About the application

Application number: 2021/93287	
What is the application for?:	Outline application for erection of residential development
Address of the site or building:	Dry Hill Farm, Dry Hill Lane, Denby Dale, Huddersfield, HD8 8YN
Postcode:

DRAWING DESCRIPTION  
PROPOSED SITE PLAN  
4 DWELLINGS

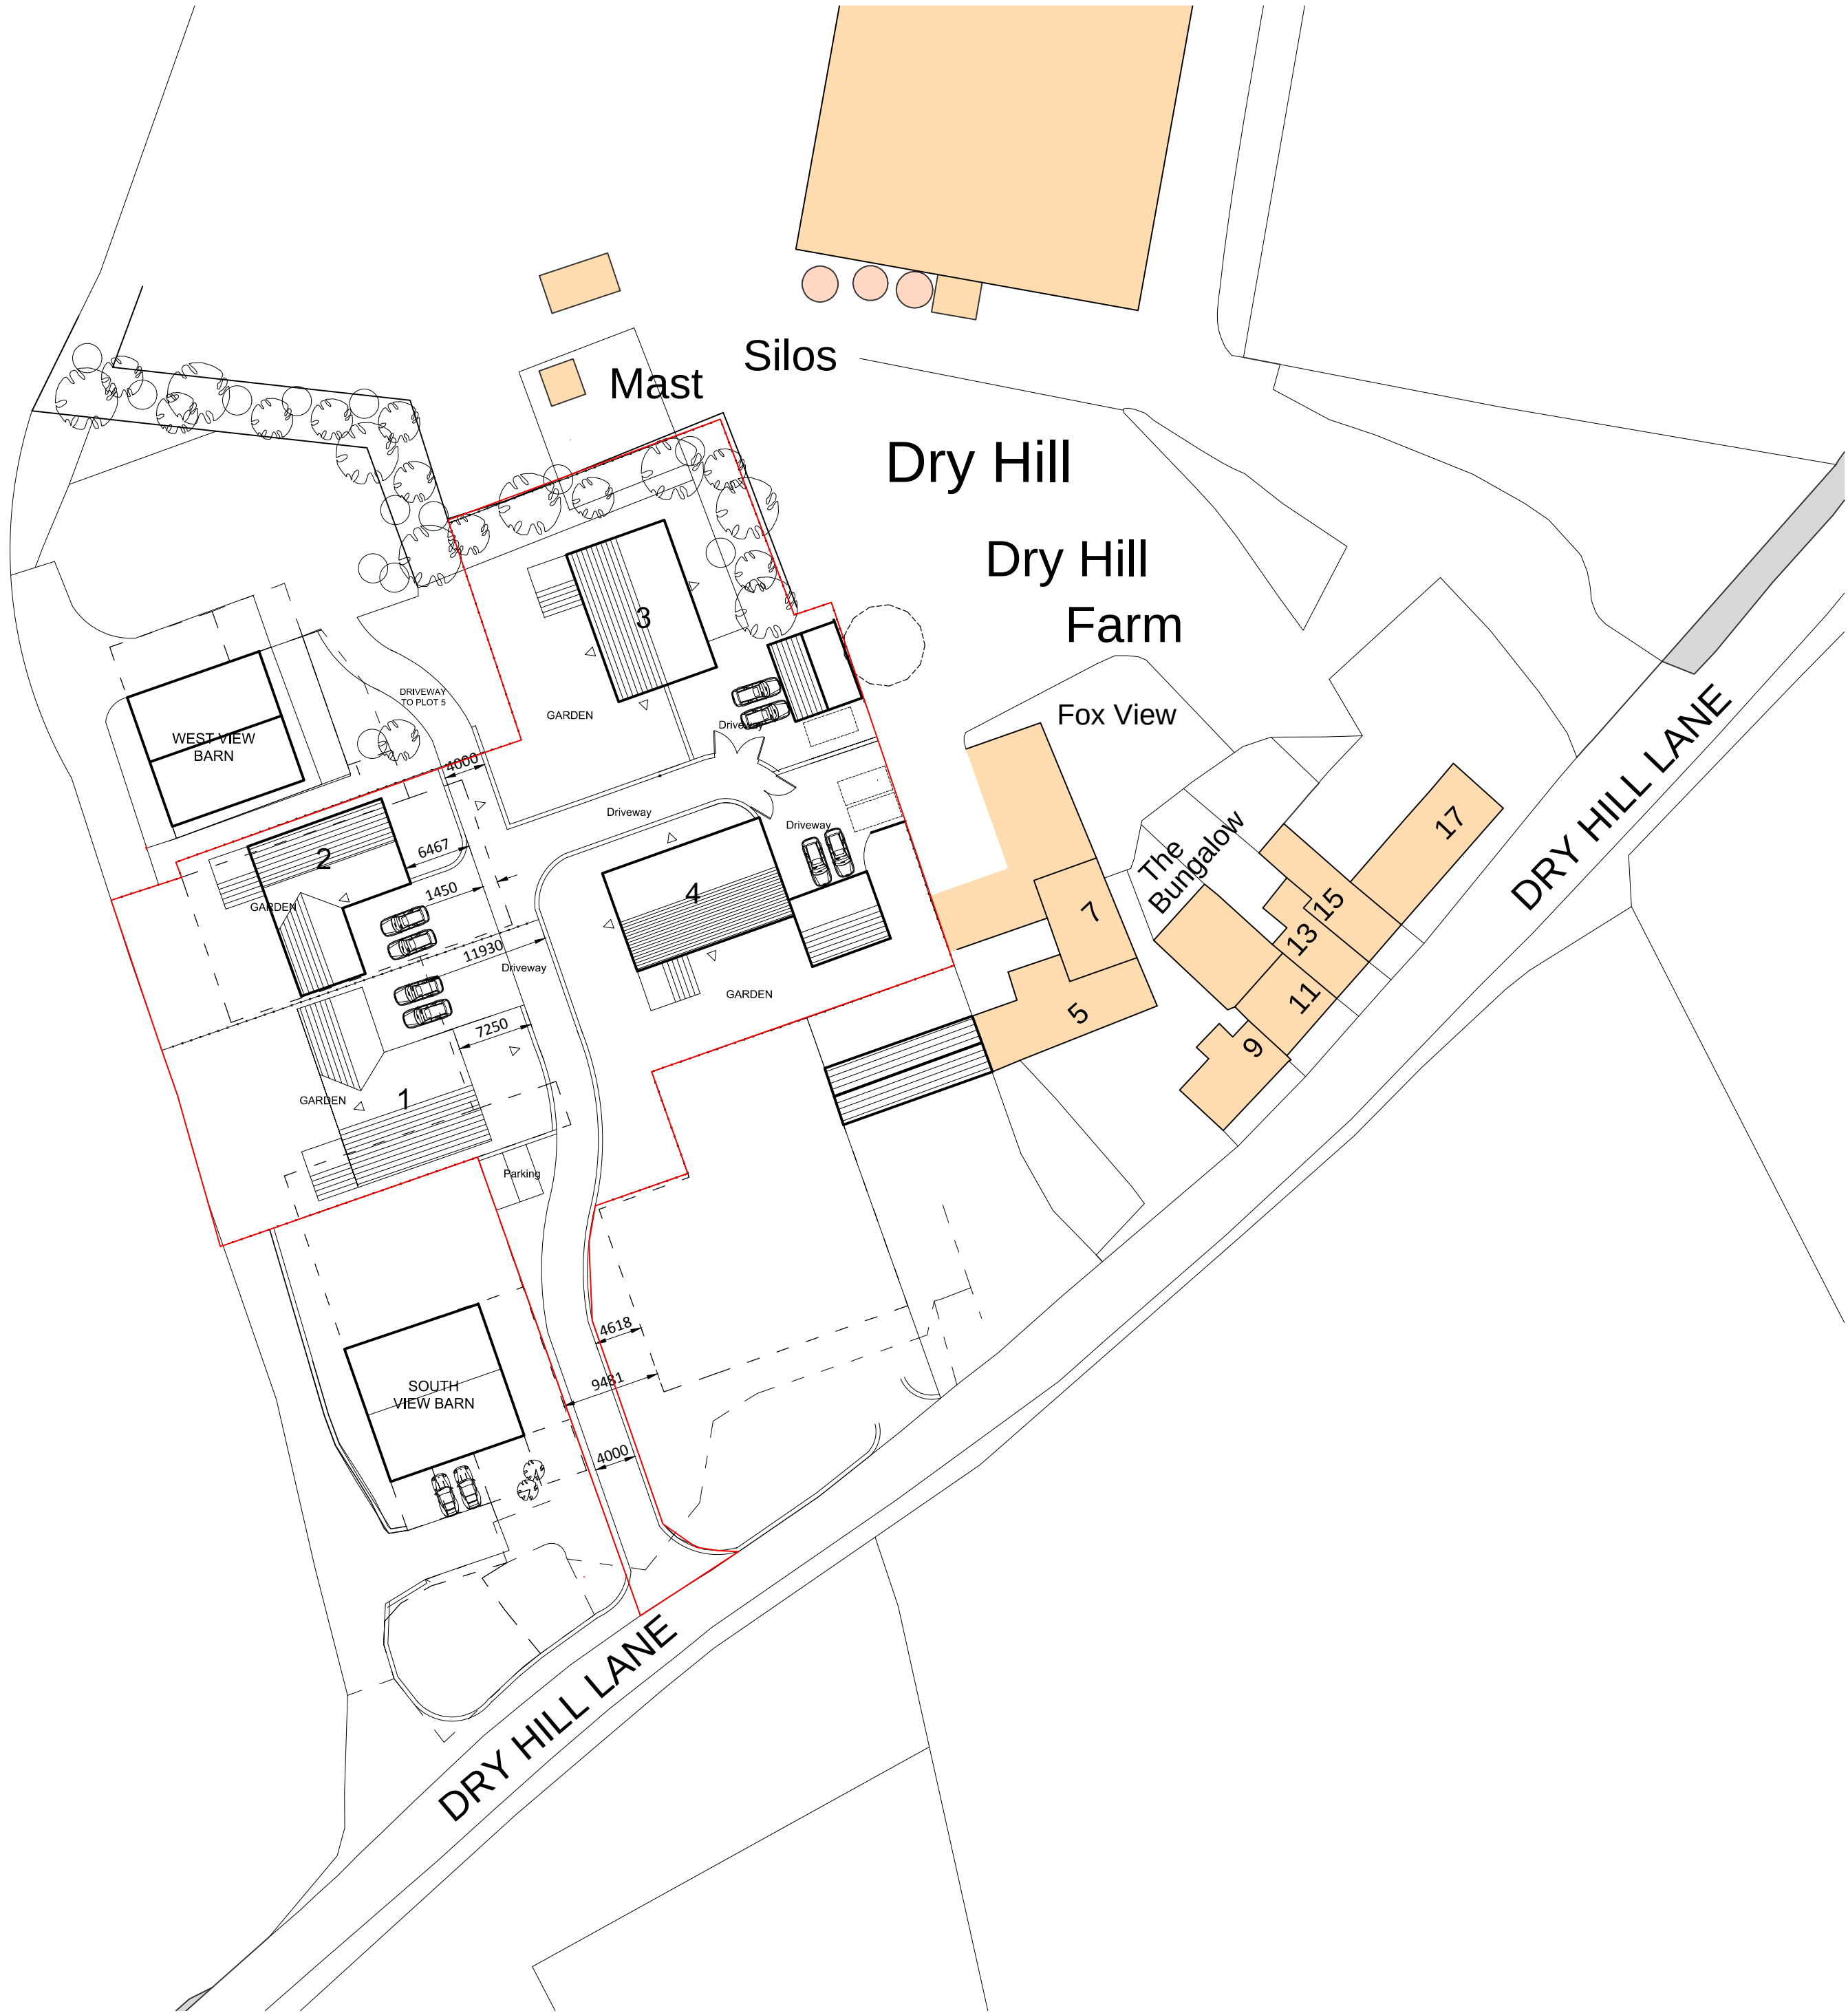
Type of comment: An objection	
Do you wish your comments to be published on the website anonymously?	<input type="checkbox"/> Yes
<p>The out line planning permission on the plans the out line enter our land. if you look on the land registry they are on our land. There are the caravan plans and then the plans for the development the original plans are in line with the boundary lines and what is actually on our land registry plans but each planning permission Mr Simon Blyth puts in is more and more on too our boundaries. And further too our complaint we would of liked too have converted a mistal which adjoining our house but was told by Nia who was our planning officer we would have to take it down please tell me if there was only going to be windows looking on too our house and our business with no windows facing the farm house out the adjoining barn why was we told this when Mr Blyth seem like he can just do what he wants.</p> <p>When he's completely altered the structure of the whole farm and put up a boundary mound of soil all the way around which he did not obtain and planning permission and who knows what has been put on the mount to make a boundary wall. It runs right up the side of Buckleys dairy.</p> <p>Which we always apply by the rules and apply for planning permission at all time. But yet we can not have what we want.</p> <p>I hope you take our objections and look at them at these house don't just over look us but over look the farm house and the adjoining barn.</p> <p>Kind regards</p>
